8 June 2022

## **HEXHAM LONG TERM TRAIN STABLING FACILITY (LTTSF) – MODIFICATION REQUEST (SSI-6090-Mod 2)**

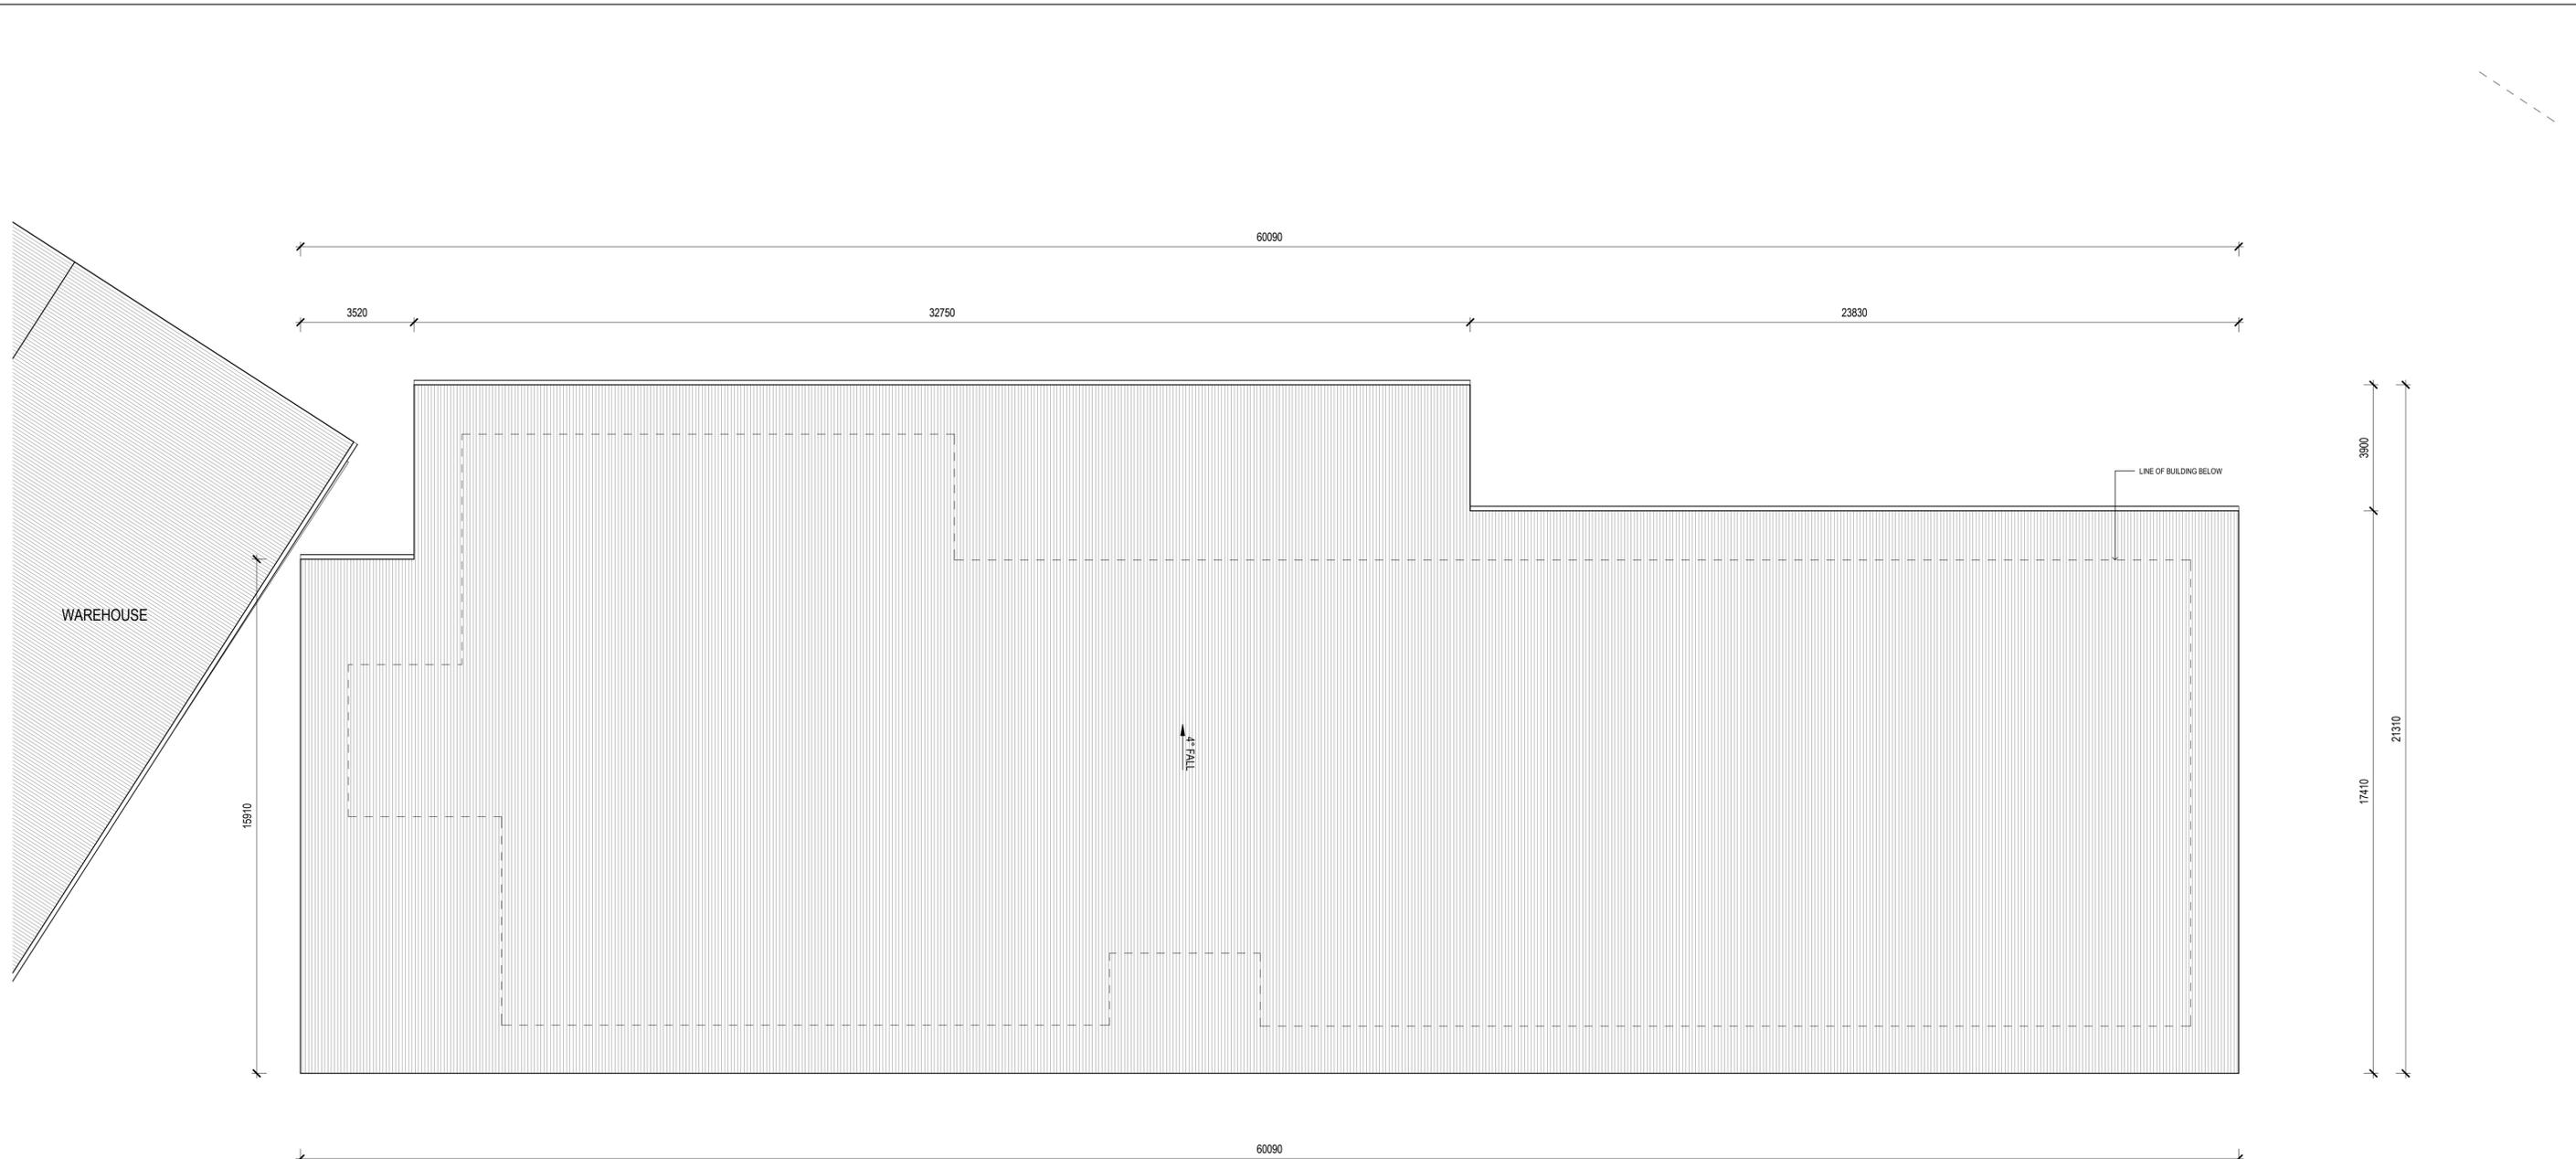
1. *Provision of a rainwater tank configured such that:*
  - a) *The total capacity is sized in accordance with Table 3 of Section 7.06 of the NDCP. For the proposed warehouse roof area of 643m<sup>2</sup> and depot roof area of 1175m<sup>2</sup>, a total storage capacity (including airspace) of 72,720 L is required.*
